## MEMORANDUM

**TO:** Jean Fraser, Planner  
**FROM:** David Senus, PE  
**DATE:** January 25, 2016  
**RE:** 31 Fore Street, Preliminary Level III Site Plan Application

Woodard & Curran has reviewed the Preliminary Level III Site Plan Application for the proposed 4-unit condominium development at 31 Fore Street in Portland, Maine. The project involves the demolition of an existing house structure and the construction of a 4-unit condominium building with ground level parking below the units.

PAVEMENT SAWCUT DETAIL
NOT TO SCALE

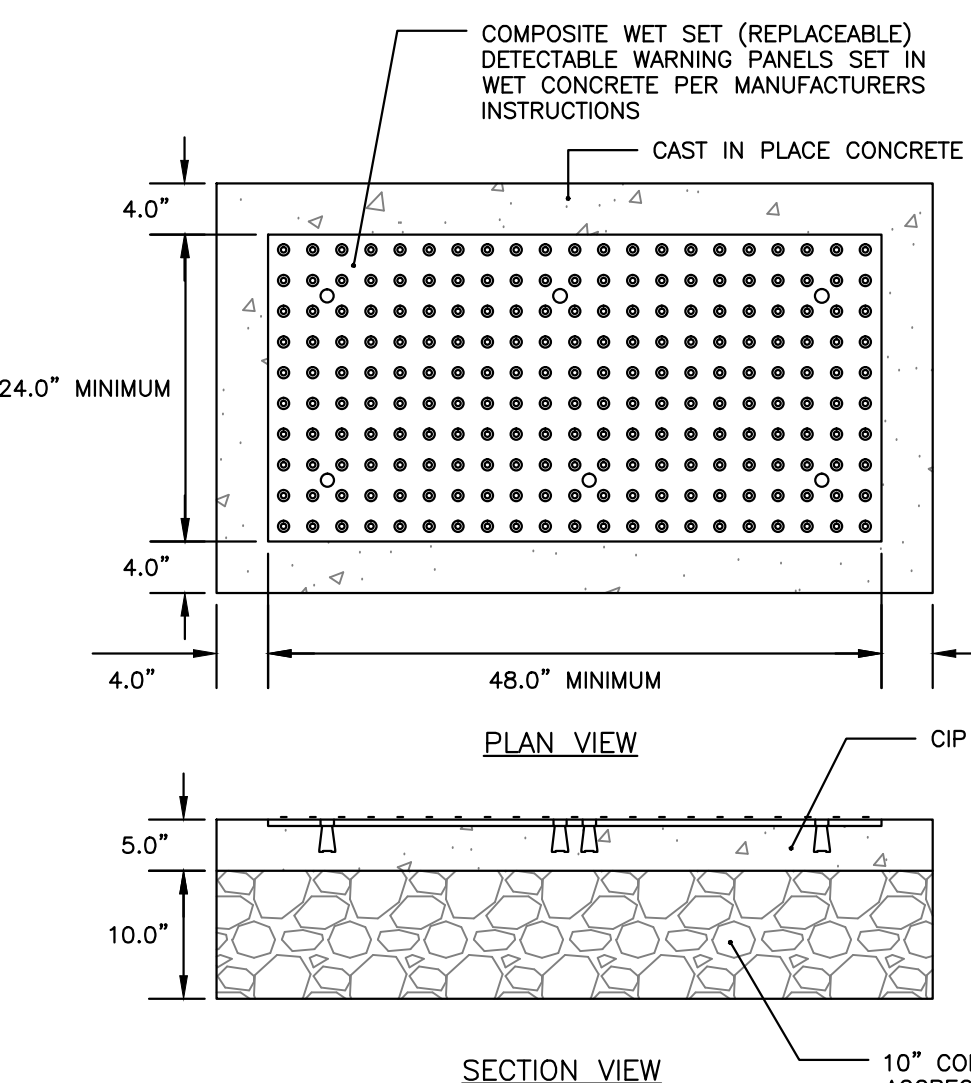
- 5) Pavement saw cut lines should be shown for the utility connections within Waterville Street.
- 6) An Oil/Water separator unit is required to treat the garage floor drains prior to entry into the City's combined sewer.
- 7) Future plans should indicate the location and connection point for the building foundation drain; this connection can be combined with the storm drain discharge from the site if preferable, but should not be combined with the sewer pipe discharge from the site.

SOIL FILTER CROSS SECTION

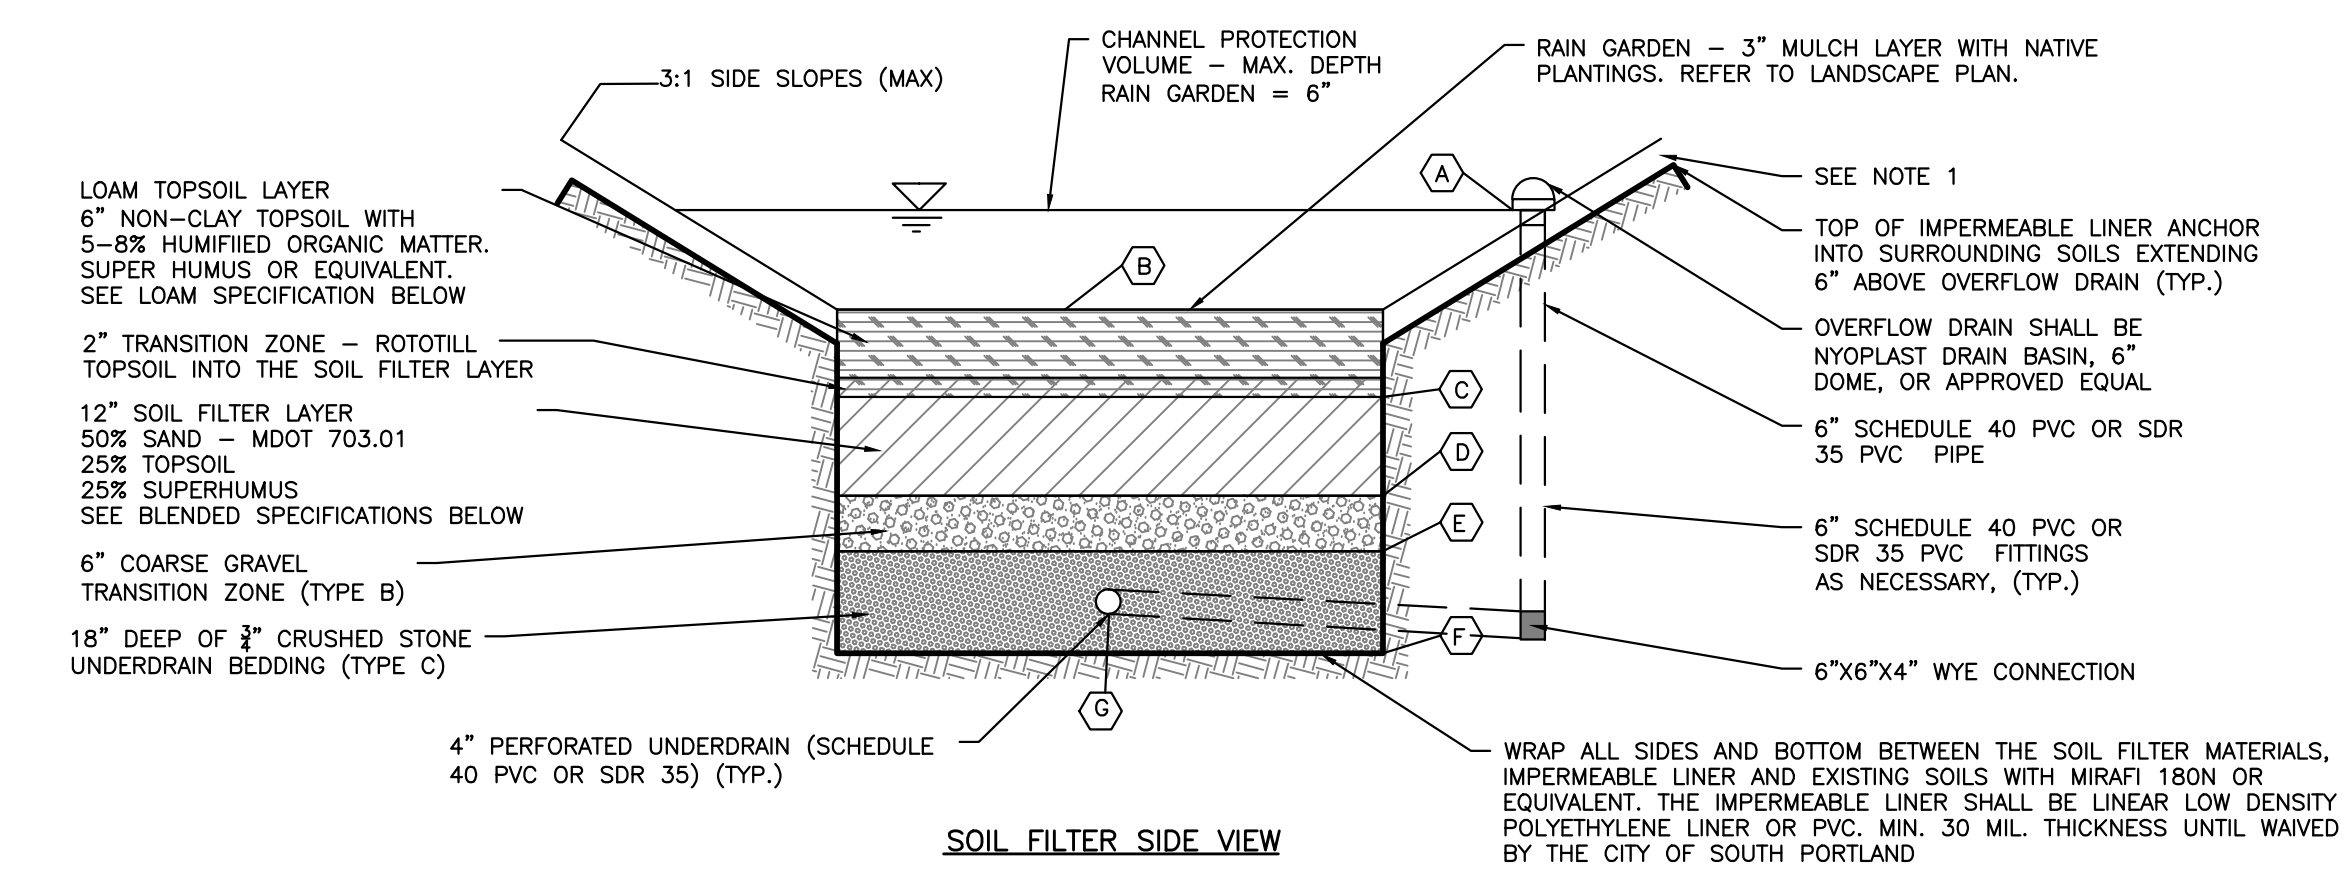
- b) General Standards: The project will result in a net increase of impervious area of just below 1,000 SF, as such, the project is not required to include stormwater management features for stormwater quality control. The Applicant has proposed to construct a rain garden to capture and treat stormwater runoff. We find this to be an acceptable approach for stormwater management for the site. We request additional grading detail be added to the site plan in and around the rain garden to understand how the rain garden in-slopes will transition to the building wall and the adjacent sidewalk. Also, a stabilized discharge location for the roof water into the raingarden should be identified in the Final submittal.
